Application for Planning Permission for Works or Extension to a Dwelling

Development: Rear Single Storey Extension
Location: 34 Mallon Dene Rustington BN16 2JR

PLANNING

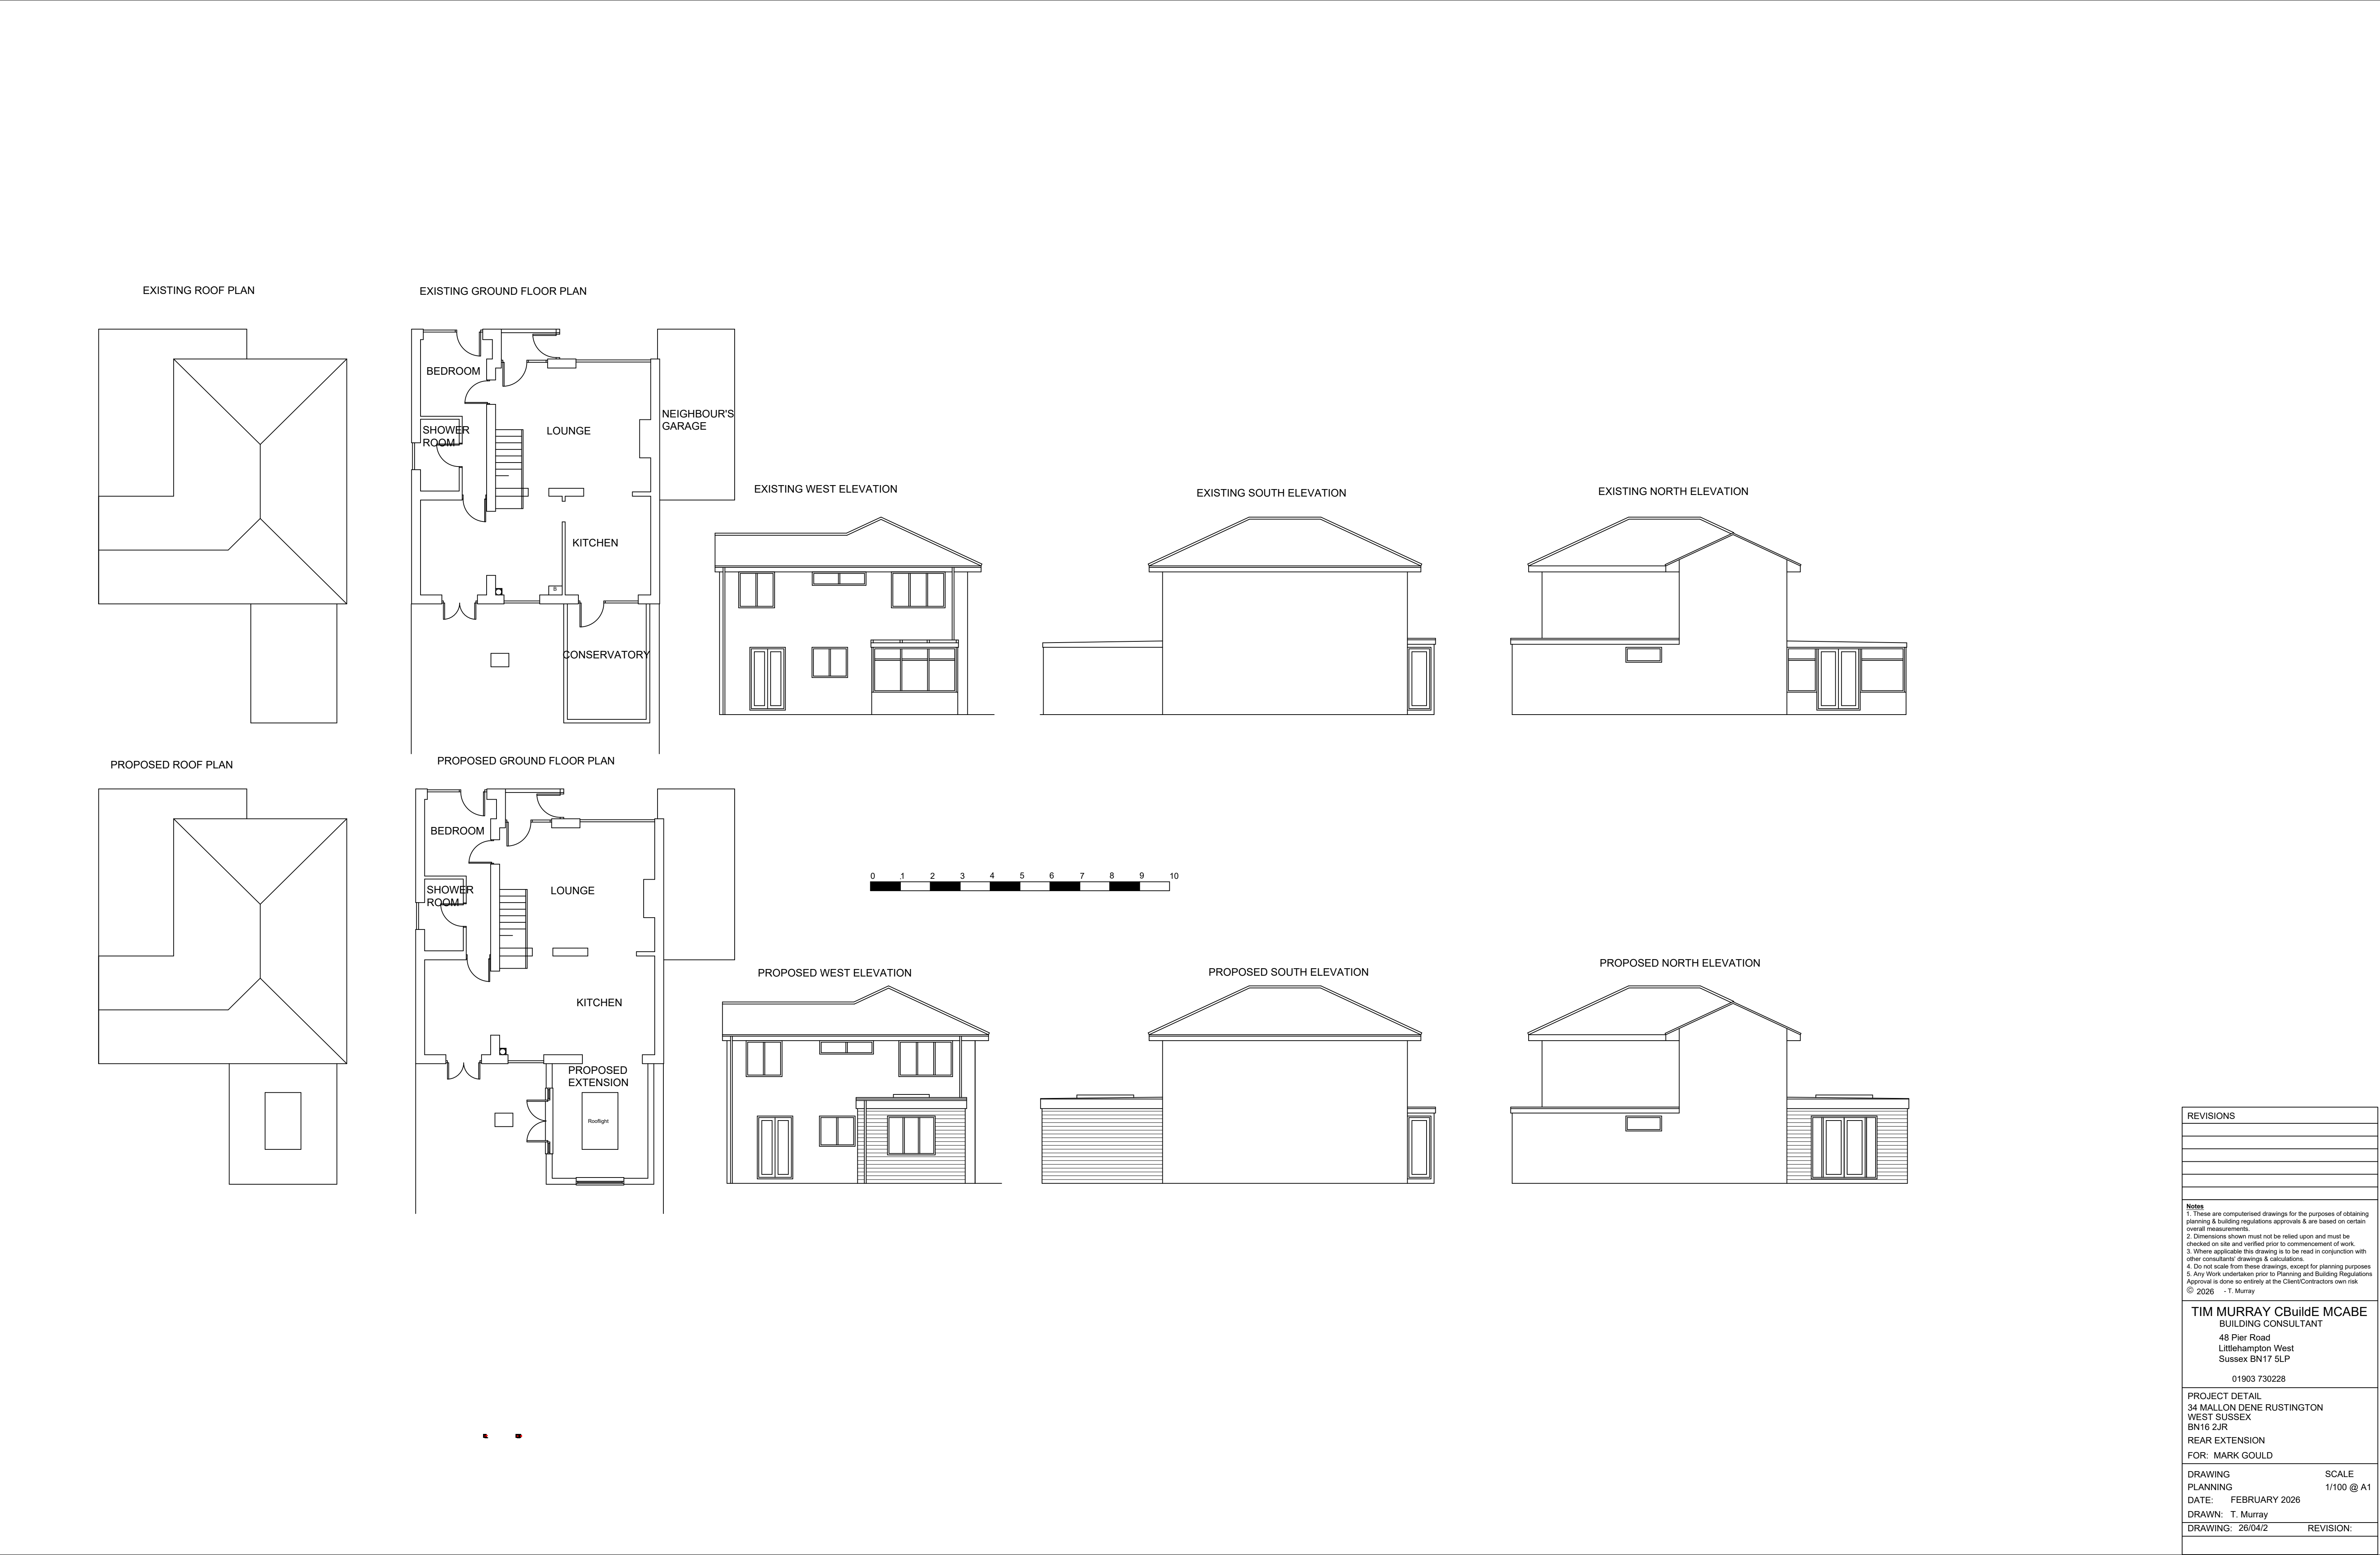
Block Plan

You are required to have dimensions from the proposed extension(s) to all site boundaries. Please amend.
